Beacon Fen Energy Park – Development Consent Order

Application reference: EN010151

Document: Deadline 4 – Response to ISH3 (Agenda Item 4 – Land Use; Agenda Item 6 – Cumulative Effects): clarification of engagement record, ALC evidence and cumulative risk

Diagram 3

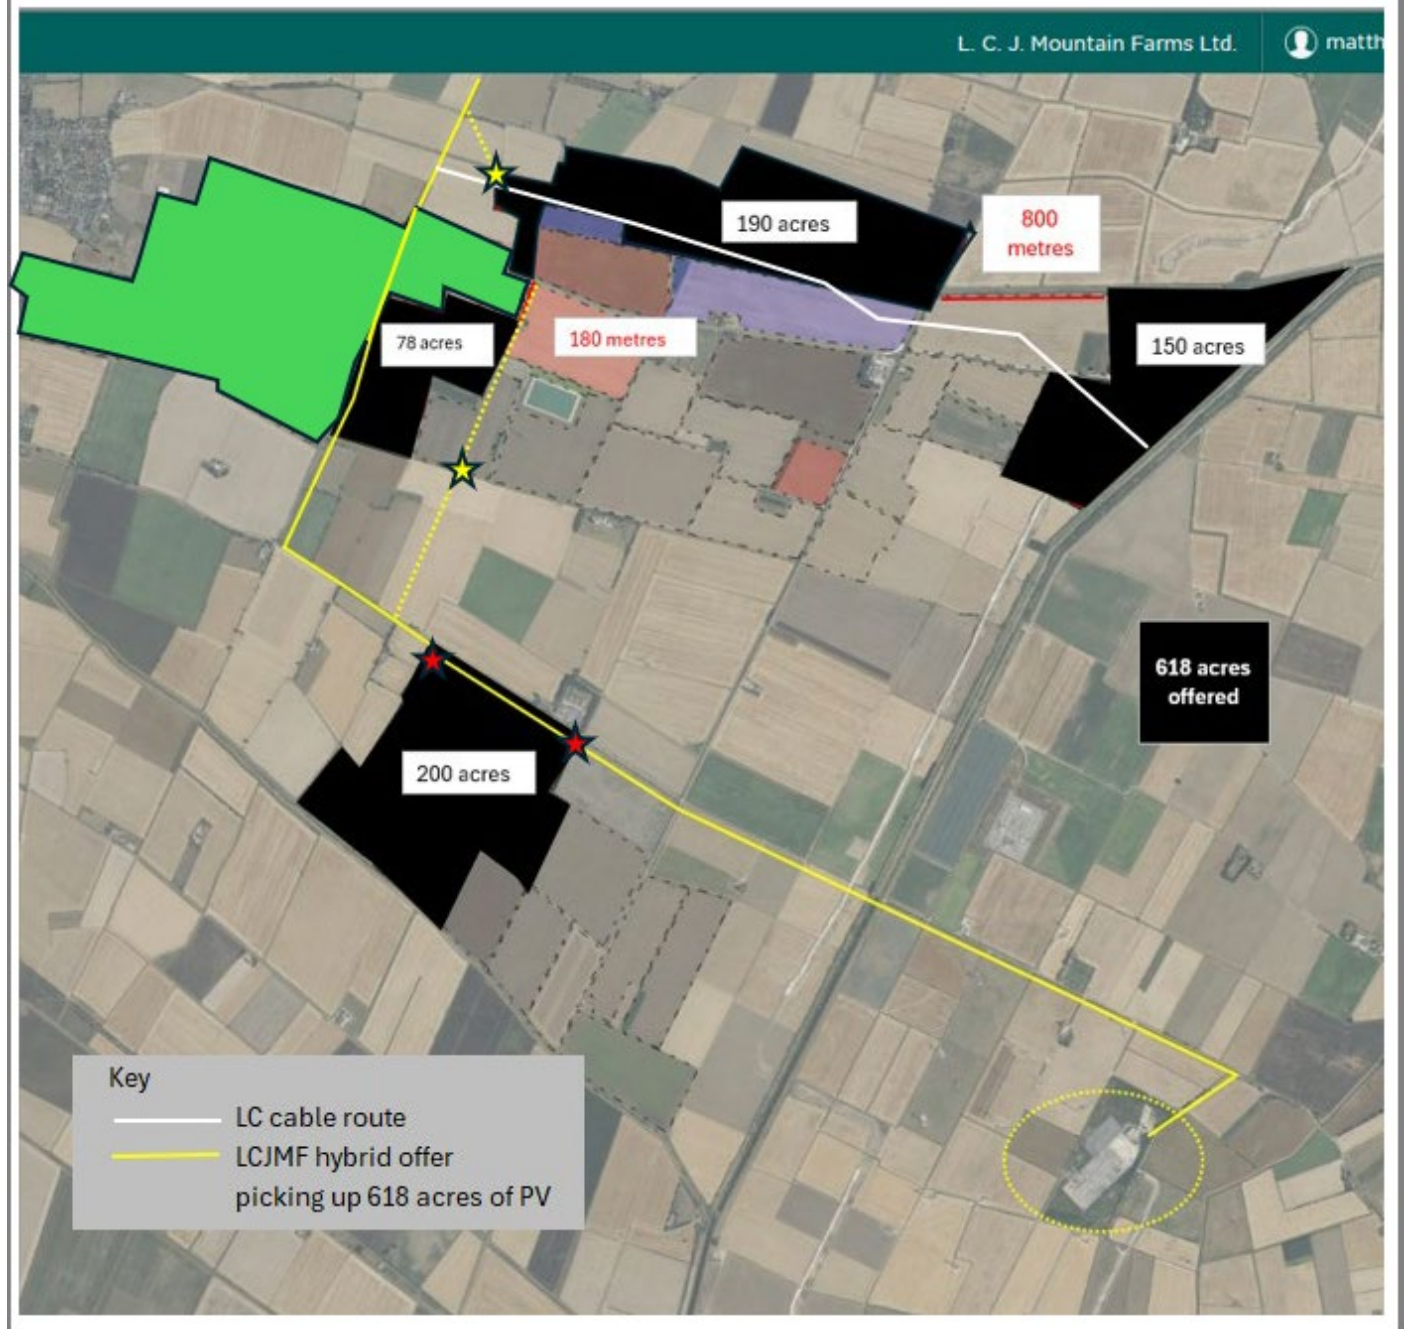
Separately at D4, LCJMF has submitted a short note titled *"Matrix Comparator Clarification (LCJMF Hybrid) and Targeted Rule 17 Request"* to fix the LCJMF comparator [yellow dotted line in REP2-051, page 15 (ExD2.11)] for the Applicant's matrix and explain the proposed "Core-12" comparison.

Source: Email from James Turley (Low Carbon) to LCJMF, 27 November 2021. © LCJ Mountain Farms Ltd 2025.

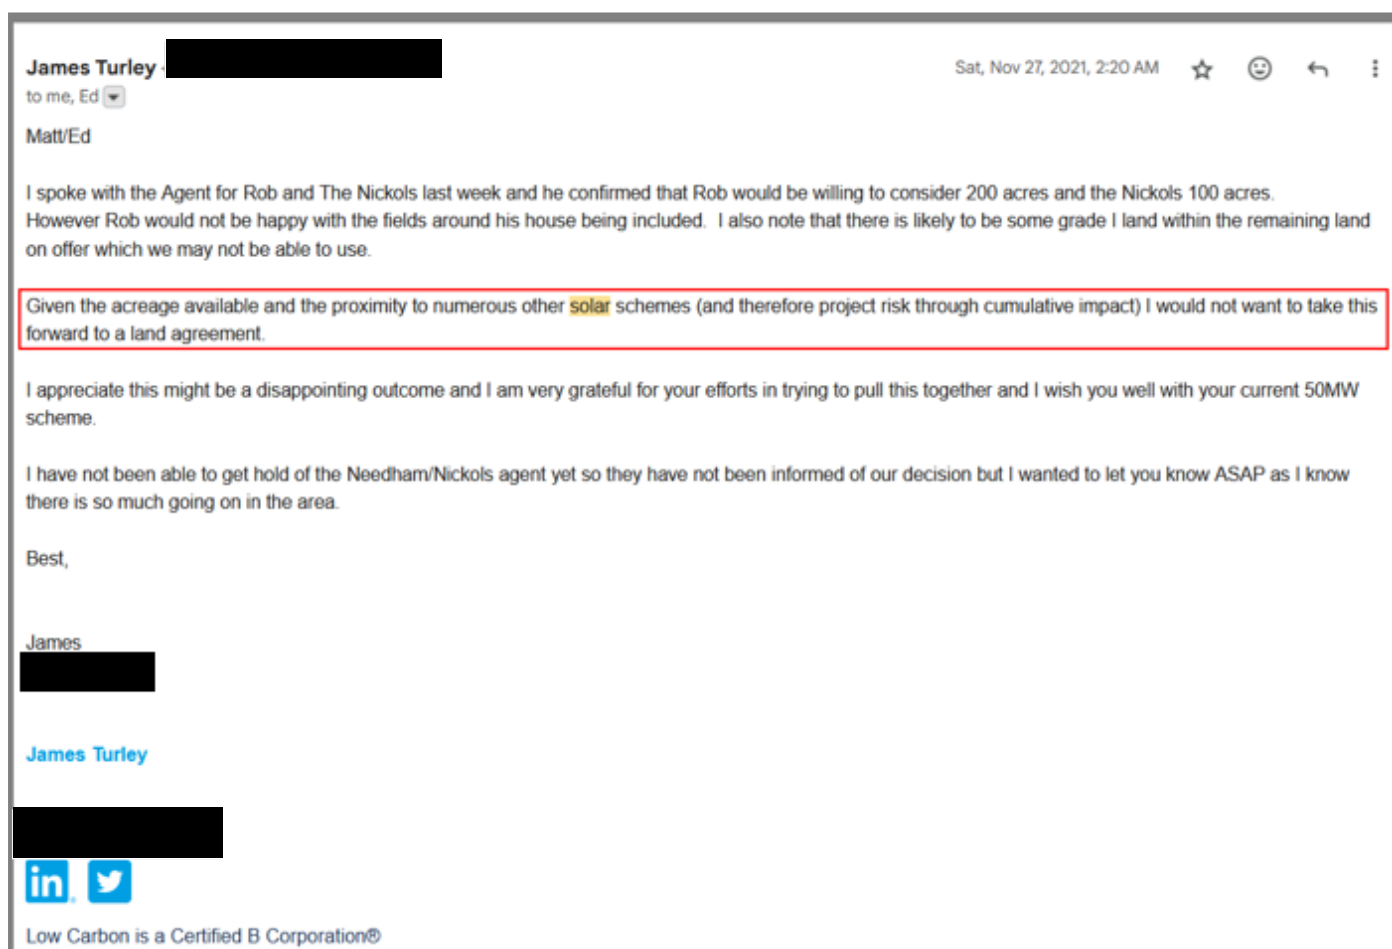
- **Cumulative effects – cluster scale:** In November 2021, when LCJMF offered circa 516 acres for a solar + BESS scheme, Low Carbon declined, expressly citing "**proximity to numerous other solar schemes (and therefore project risk through cumulative impact)**" (email from James Turley, 27.11.2021 – ExD4.6). By contrast, ES Chapter 18 [APP-069] now concludes that cumulative effects of a 400 MW solar + up to 600 MW BESS NSIP in essentially the same geography are acceptable. TEC Register extracts for Bicker Fen (ExD4.10) show committed capacity rising from c.100 MW in January 2021, to c.900 MW in October 2022, to over 2 GW of associated solar/BESS by August 2024 – an increase of more than 2,000%. LCJMF finds it difficult to reconcile that trajectory with the earlier view that there was already "project risk through cumulative impact".

Extract from the Applicant's Voluntary Negotiation Status Plan (Document 9.12, Ref. EN010151-000605) showing LCJMF's status as "Heads of Terms in discussion – not likely to be agreed prior to close of examination"

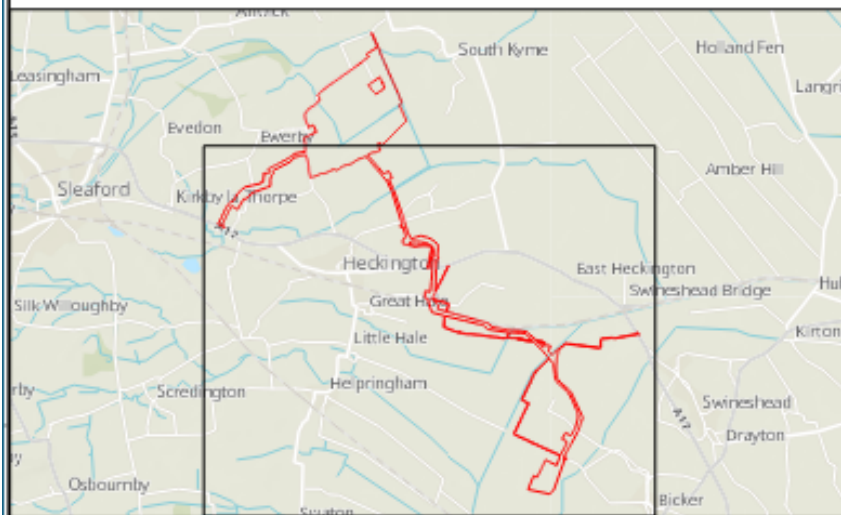
3.8. That impression is reinforced by the Applicant's own Voluntary Negotiation Status Plan (Document 9.12, Ref. EN010151-000605). On that plan, LCJMF appears as the only affected party recorded as having heads of terms "in discussion" but "not likely to be agreed prior to close of examination", notwithstanding the 3.2 km length of cable across LCJMF's titles and LCJMF's sustained efforts to engage (ExD4.7). Against the background of only three short online meetings and a handful of emails over some 2½ years, LCJMF finds it difficult to reconcile this status with the Applicant's suggestion that there has been extensive and effective engagement with this landowner.

ExD4.8

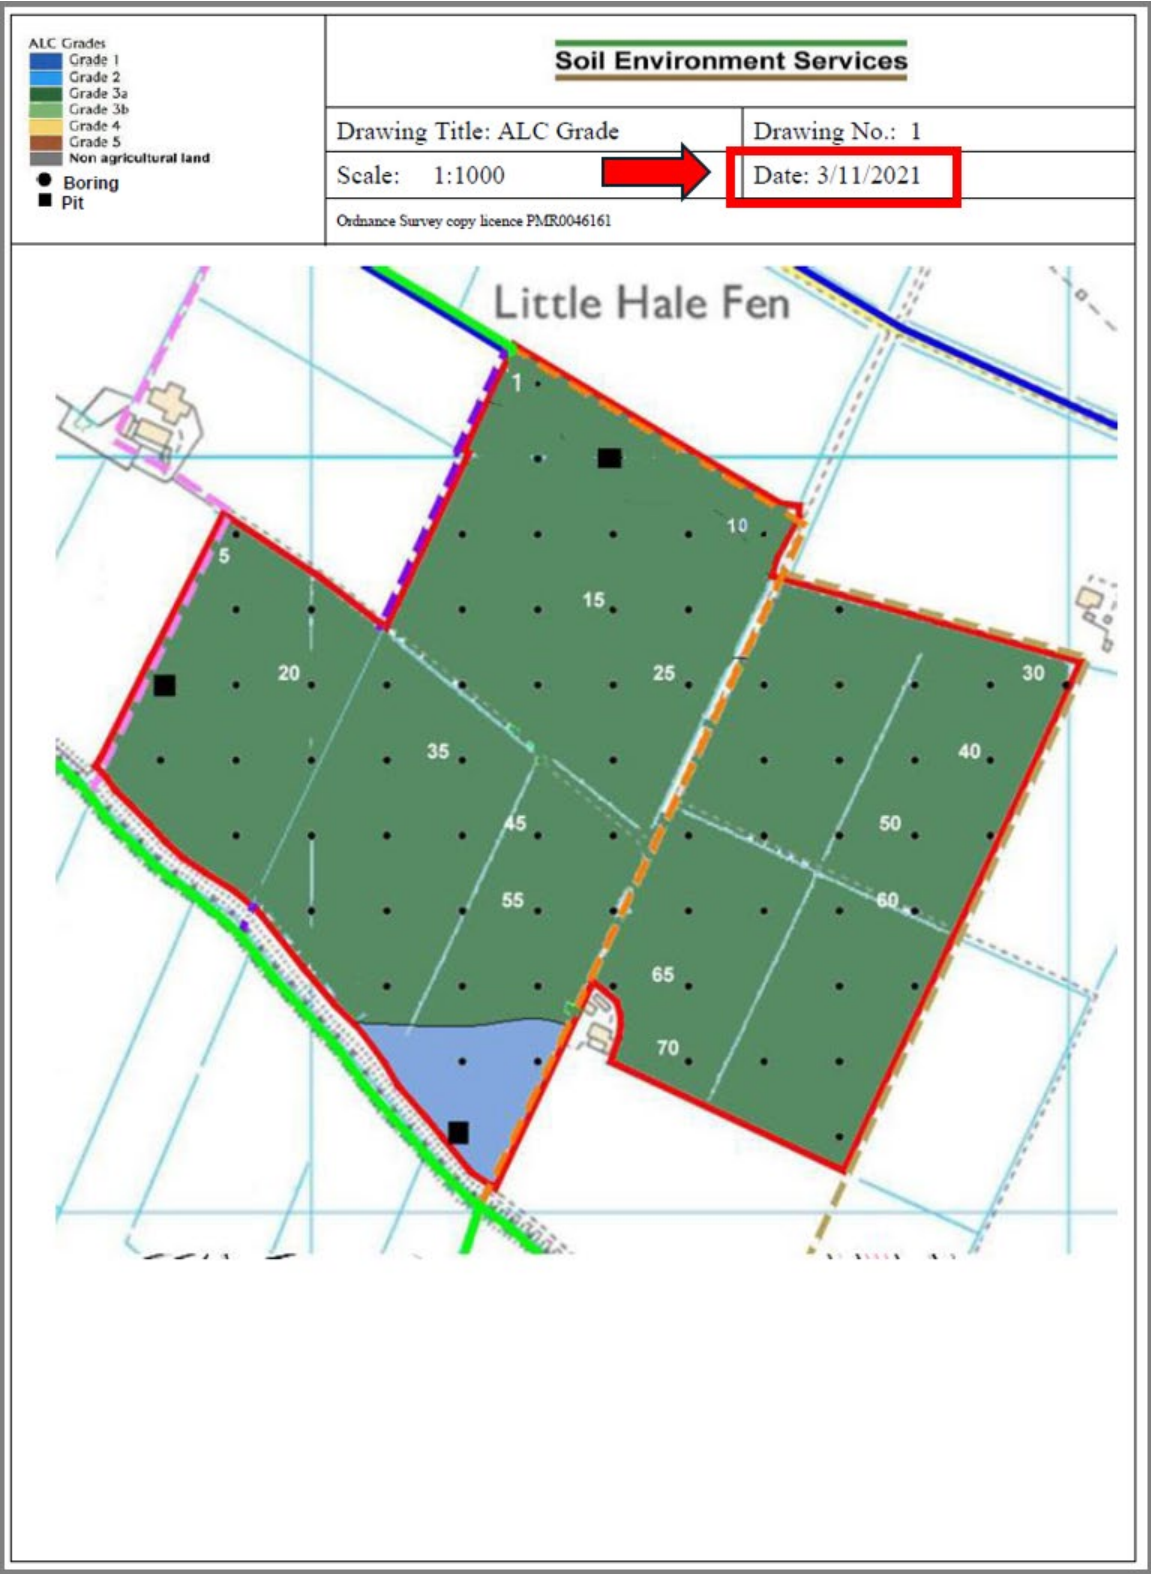
- **Agricultural land classification and Appendix 3.1:** LCJMF reiterates that the Applicant’s reliance on national ALC mapping understates the extent of lower grade BMV land and non-BMV land in the area. The AGR3 site-specific ALC survey (Soil Environment Services, 03.11.2021 – ExD4.8) shows the 200-acre AGR3 site, directly relevant to the LCJM Nov 21, LCJM Aug 23 and LCJM Hybrid cable corridor, as 96% Grade 3a. This aligns with LCJMF’s 30-year farming records but is not reflected in the Applicant’s national dataset. LCJMF also notes that the LCJMF Hybrid route (the yellow dashed line in previous submission REP2-051, ExD2.11) deliberately tracks **just outside the darkest Grade 1 band** (ExD4.9b). Even on the Applicant’s own mapping, the LCJMF Hybrid cable route therefore improves the EN-1 / EN-3 position by better avoiding higher-grade Best and Most Versatile land compared with the chosen Option 1. ES Appendix 3.1 Cable Route Corridor Appraisal

(Doc Ref 6.3.9) itself records no clear preference between the main options on soil quality and prefers Option 1 on the basis that it is the shortest, most direct route, affecting the least total area of agricultural land in kilometres. LCJMF submits that, once the AGR3 ALC survey and farm-specific evidence at Bicker are taken into account, the LCJMF Hybrid, not Option 1, in fact better minimises interaction with higher grade BMV land on LCJMF's holding. LCJMF further notes that the "Additional Alternative Cable Route Corridor" dismissed in Appendix 3.1 is a Little-Hale-Drove / Option-3-type alignment, not the LCJMF Hybrid as now fixed by the yellow dotted line in Rep2-051, page 15, (ExD2.11), so the Applicant has never actually appraised the LCJMF Hybrid in the like-for-like manner now requested by the ExA.

ExD4.11

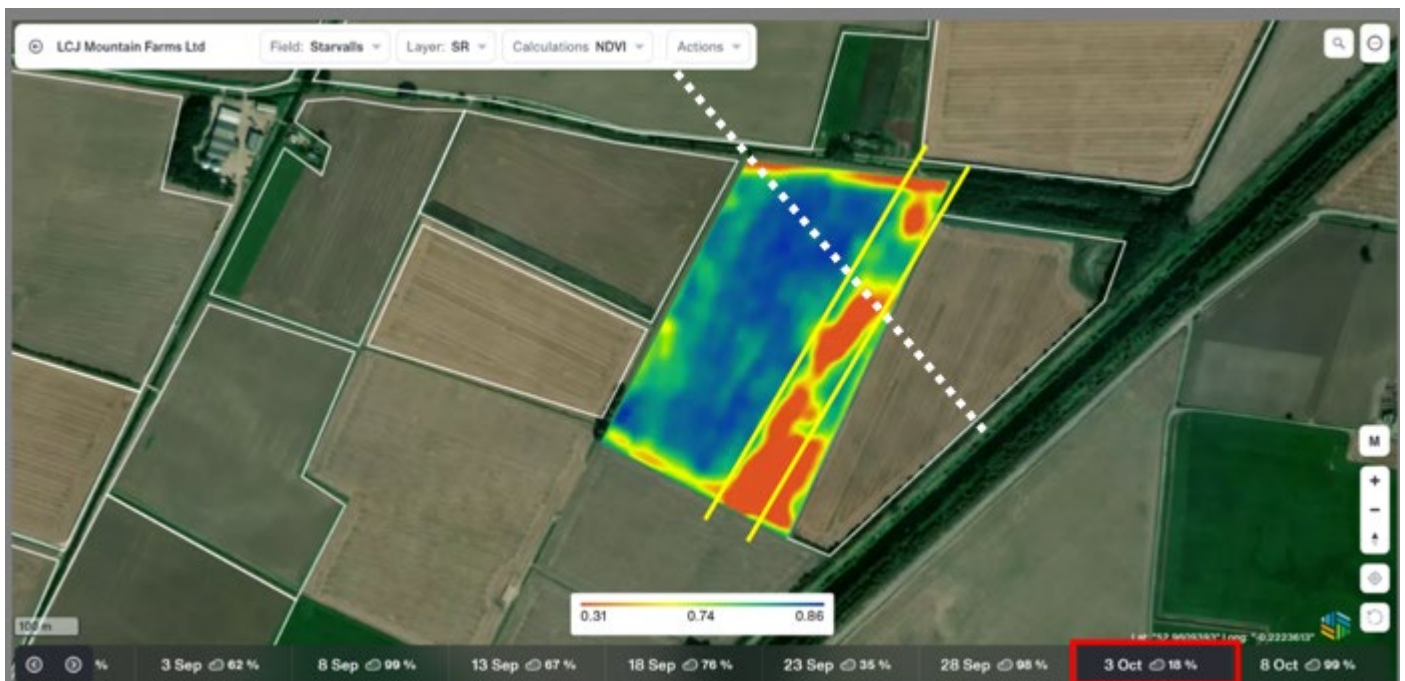
- **Cumulative effects – field scale at Starvalls and LWS 4722:** At Starvalls Field (TF 1941 4286), NDVI imagery (ExD4.11), post-construction soil surveys (ExD4.12) and photographs of ponding (ExD4.13) show that the reinstated Viking Link cable corridor continues to suffer degraded soil structure, crop stress and altered drainage. Beacon Fen now proposes to cross the same alignment. LCJMF submits that this represents a material cumulative risk to high-quality agricultural land that has not been fully recognised in the ES soils and cumulative assessments. LCJMF also notes a mismatch between the high-level treatment of Local Wildlife Sites in Appendix 3.1 (which relies on minimising interactions and potential trenchless techniques such as HDD) and the reality of approximately 1.19 km of construction access and cable working in close proximity to LWS 4722 on LCJMF land under Option 1, with no HDD proposed at that location. LCJMF submits that the Appendix 3.1 appraisal did not have the benefit of LCJMF's farm-specific evidence and has not transparently captured the cumulative soil and LWS interactions on LCJMF land (including at Starvalls Field and along LWS 4722).
